**Consultation Response KC Landscape**

<b>Planning Number:</b>	2023/91431		
<b>Proposal:</b>	Discharge of conditions 7 (internal roads), 8 (Church Lane crossing), 12 (electric vehicle charging), 13 (waste storage and collection), 17 (attenuation basin), 18 (flood routing), 23 (crime prevention) and <b>32 (landscaping)</b> of previous permission 2021/91571 for erection of residential development for 125 dwellings		
<b>Location:</b>	land south of, The Lodge and north of Church Lane, Linthwaite, Huddersfield		
<b>DEVELOPER/APPLICANT/AGENT:</b>	TADW Ltd		
<b>Planning Officer:</b>	Victor Grayson		
<b>Date Responded:</b>	020623	<b>Responding Officer:</b>	AR
<b>Site Area (Hectares)</b>		<b>Responding Ref:</b>	MM46

**NOTES/COMMENTS:**
**Condition 32 – Landscaping**

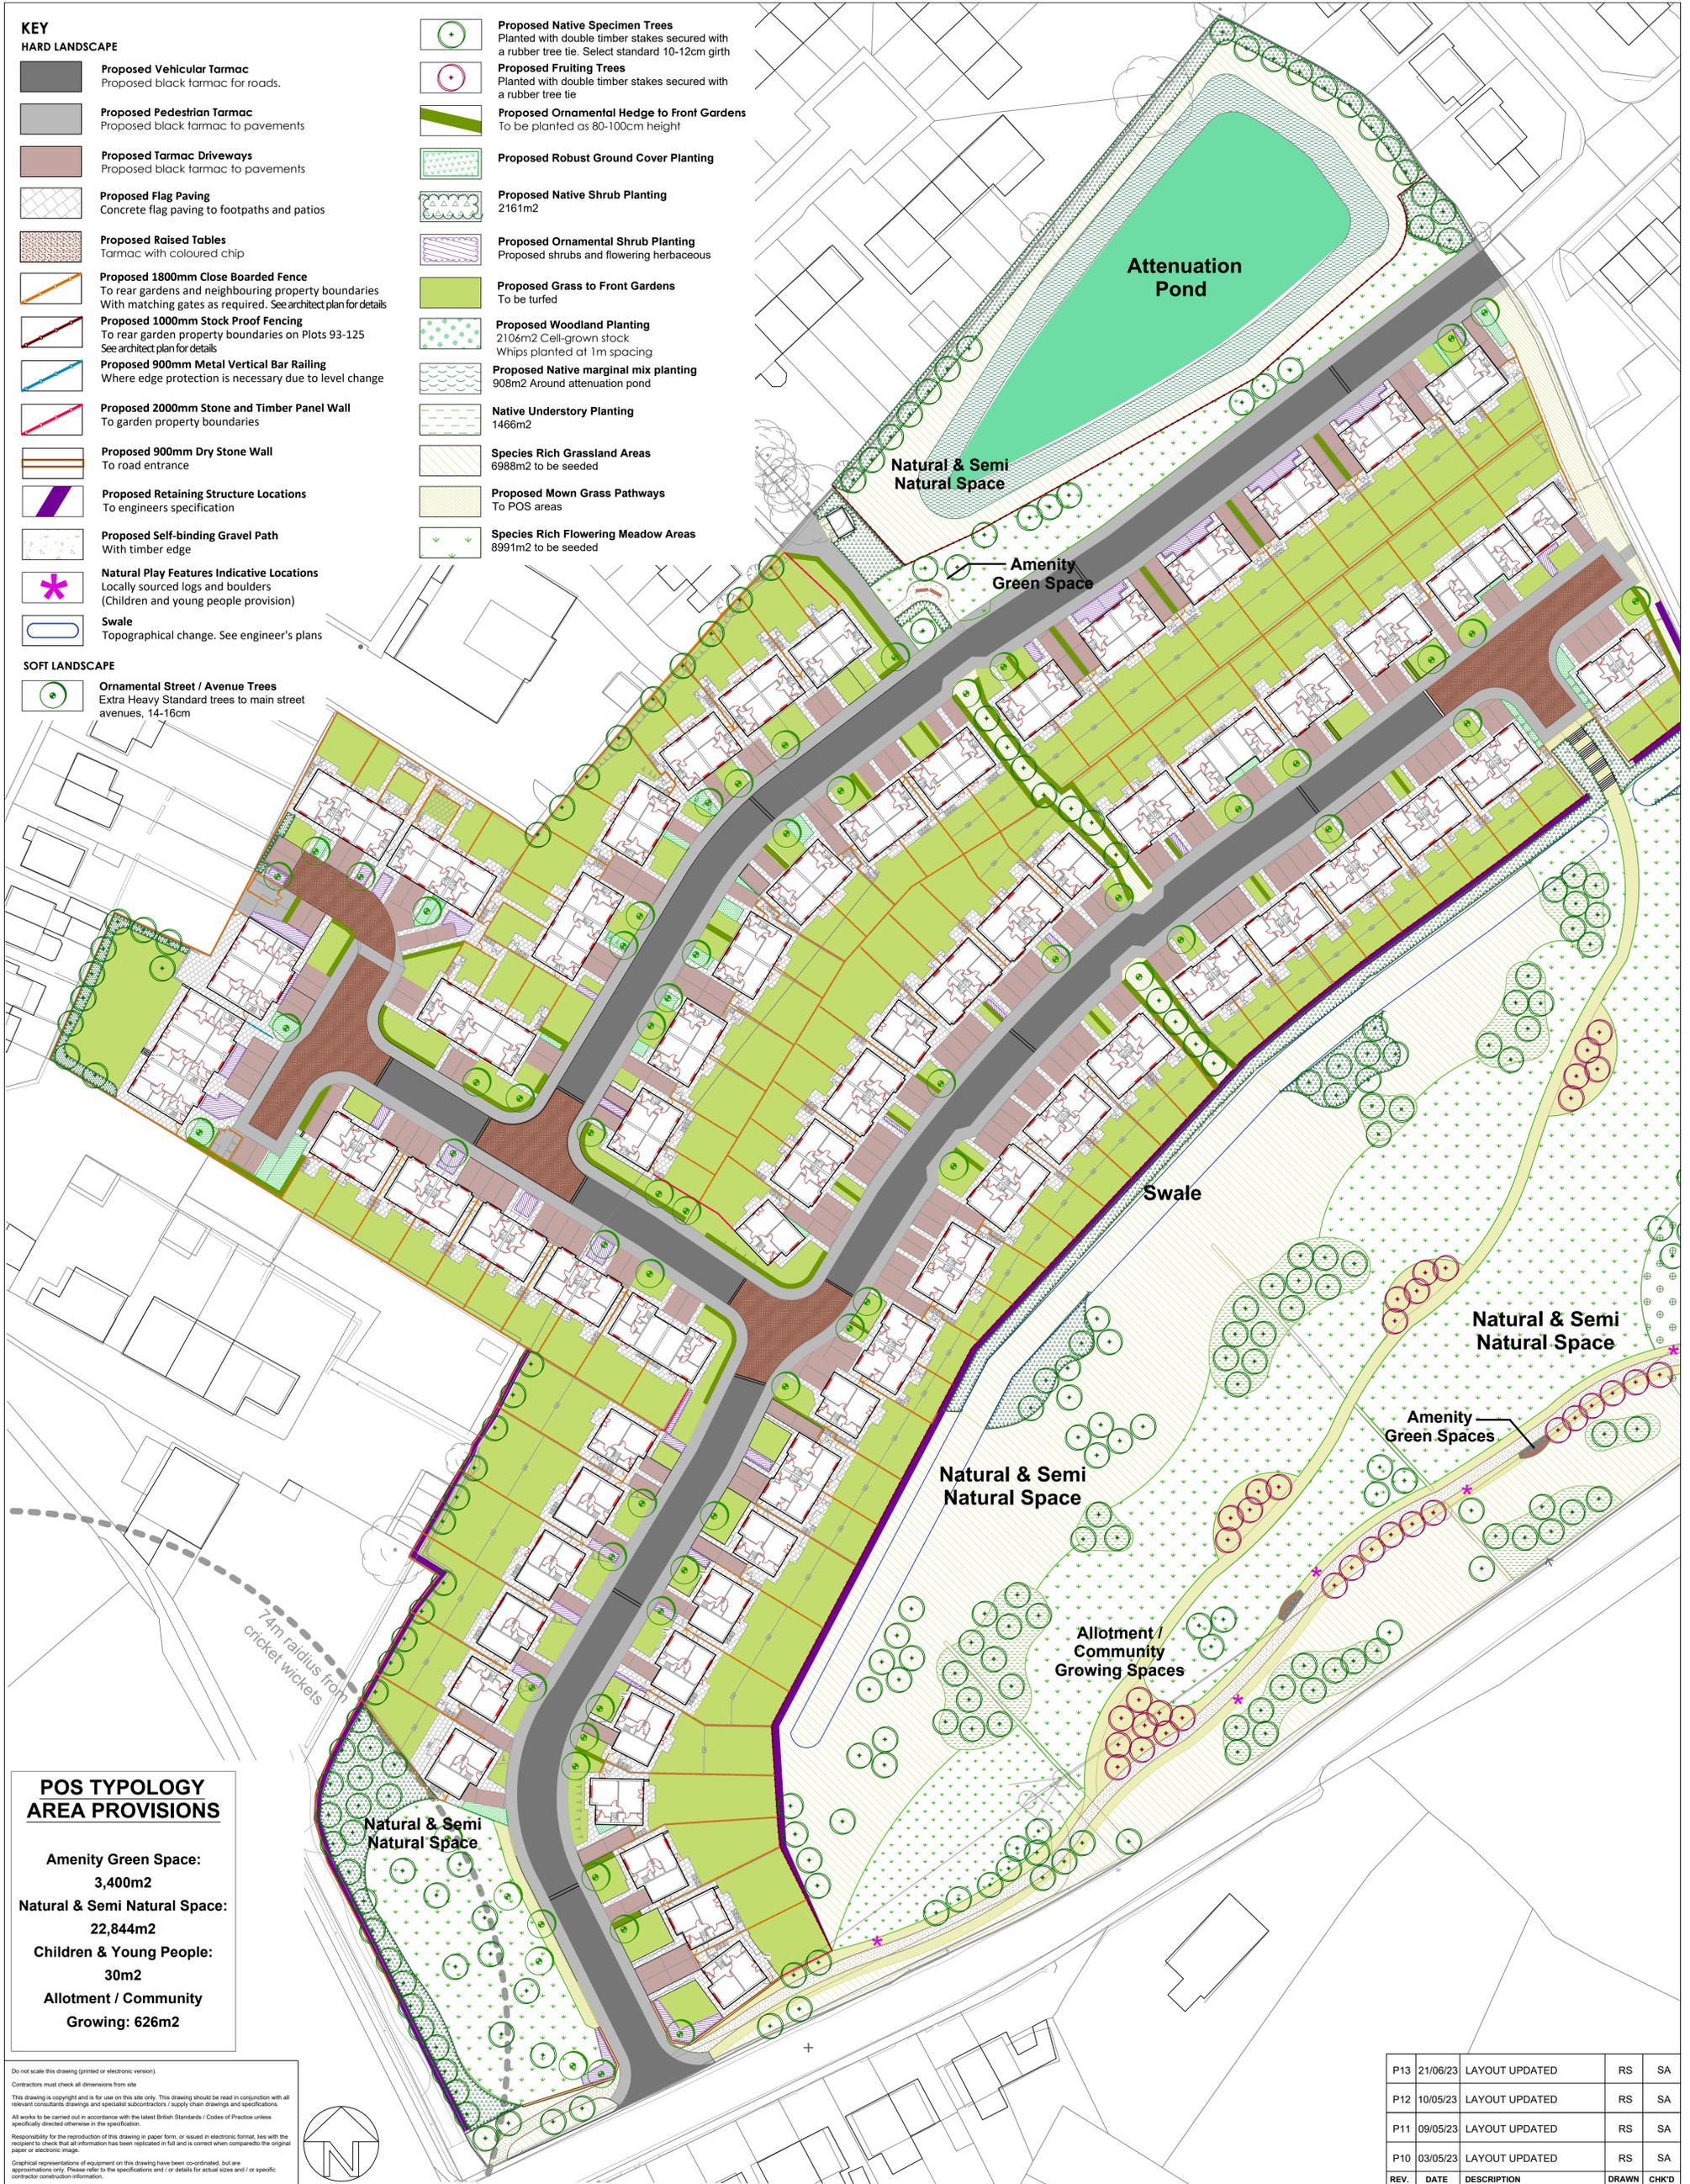
The details provided in the drawings (as numbered above) are largely acceptable for the intended purpose of condition 32. The maintenance schedule covers a period of 1-10yrs including losses/replacements. Details also confirm the required POS provisions are in line with agreements set. The soft planting plans are also considered acceptable and sympathetic to the scheme however the list does **still** include a potentially invasive species (*Lonicera pileate*), which should not be planted in this setting and should be substituted with more appropriate less invasive species as they are on the Plantlife list of species to avoid.

**We can recommend the discharge of this condition once the above minor adjustment is made to the planting list.**
